CITY OF PORTLAND, MAINE

May 27, 2015

Project Name:	Mixed Use Retail and Residential Building	Project ID:	2014-066
Address:	185 Fore Street	CBL:	020 F023001
Applicant:	Nathan Bateman		
Planner:	Shukria Wiar

Memo To: Shukria Wiar
Barbara Barhydt
From: David Margolis-Pineo
Re: 167-185 Fore Street – Review Comments 2014-066
Department of Public Services

(F) BARRIER FREE RAMP DETAILS
N.T.S.

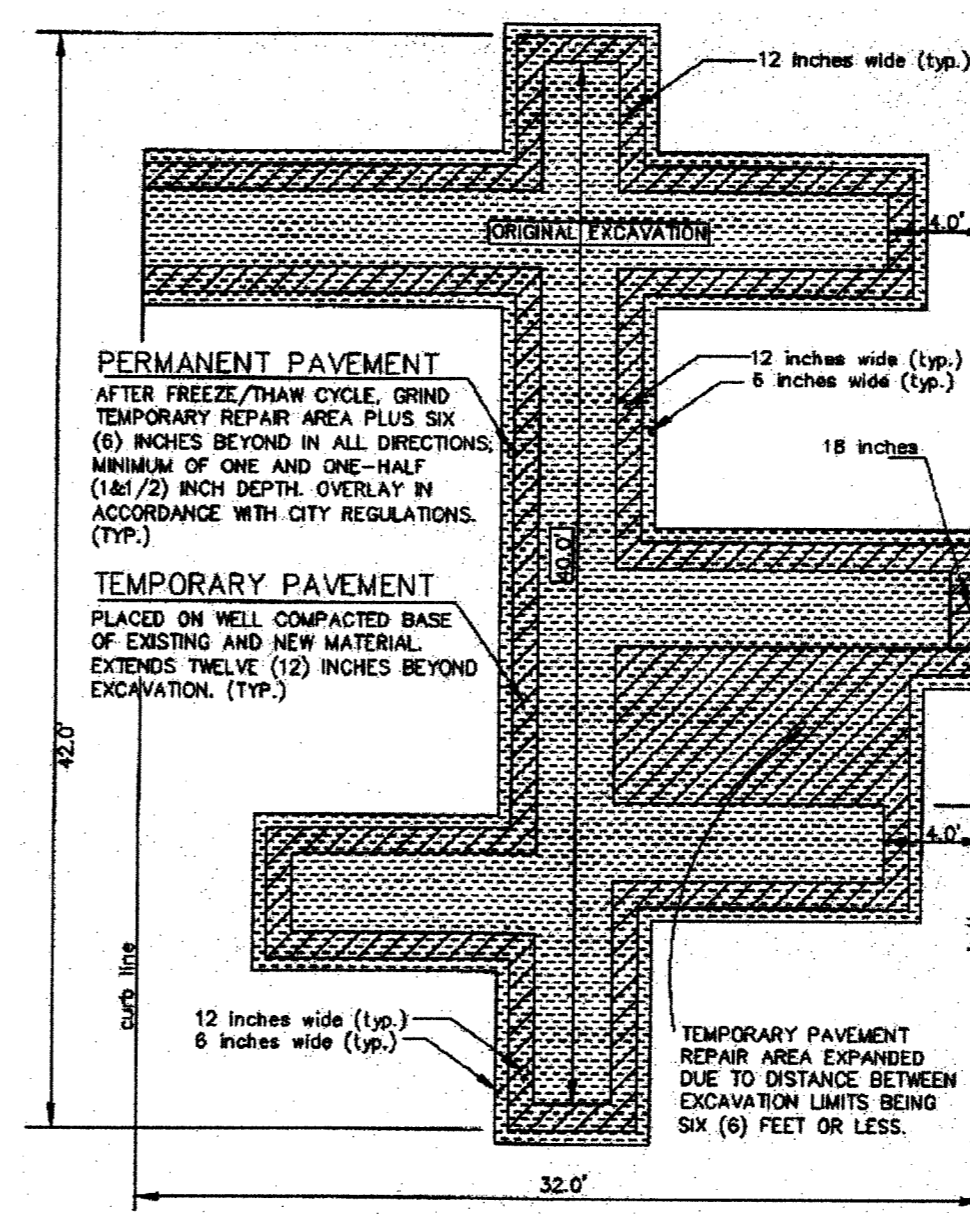
6. All proposed sidewalk crossing ramps shall be constructed to be ADA compliant.
I'm not convinced that the ramp and landing area on the North side of the Fore Street crosswalk has an adequate landing ramp. I am asking Bruce Hyman to further review.

(H) CROSSWALK STRIPING DETAIL
N.T.S.

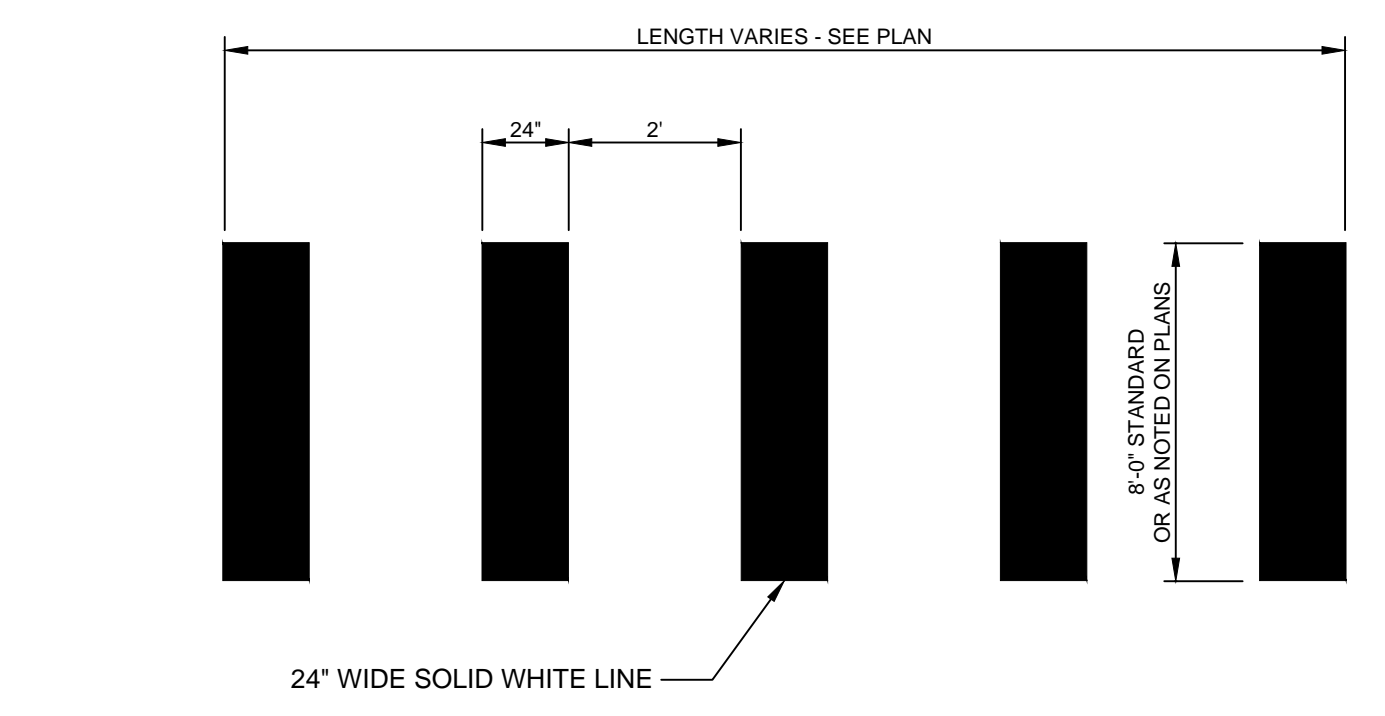
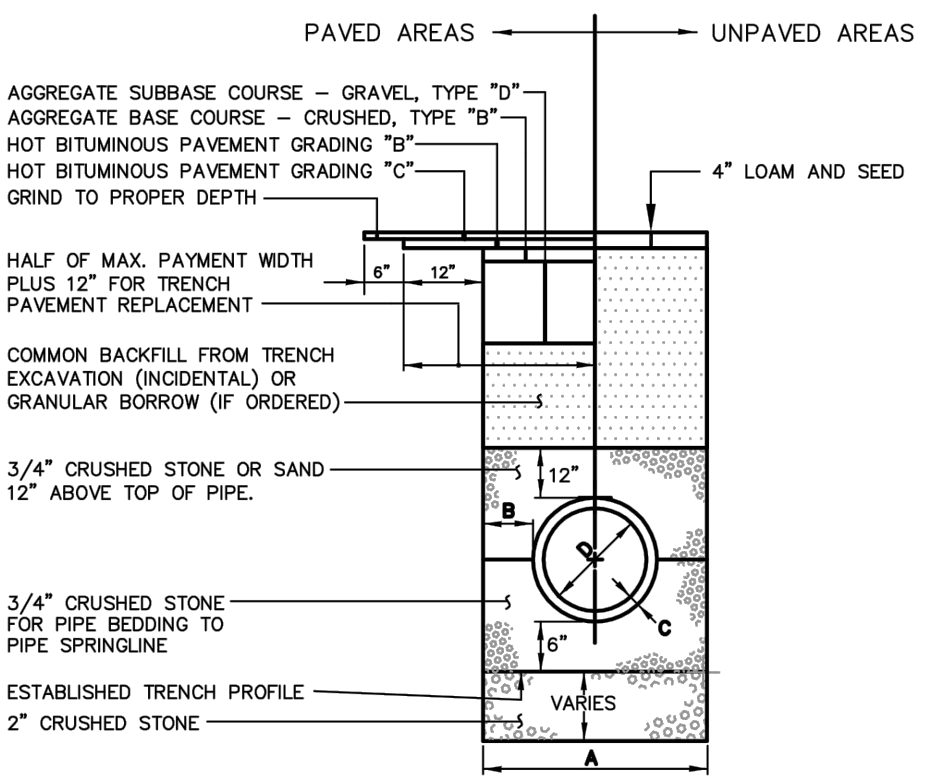
10. Cross walk marking in detail on Sheet C6.2 is incorrect. Please refer to Figure I-22 in the City's Technical Manual.
Crosswalk markings currently show City standard. Thank you
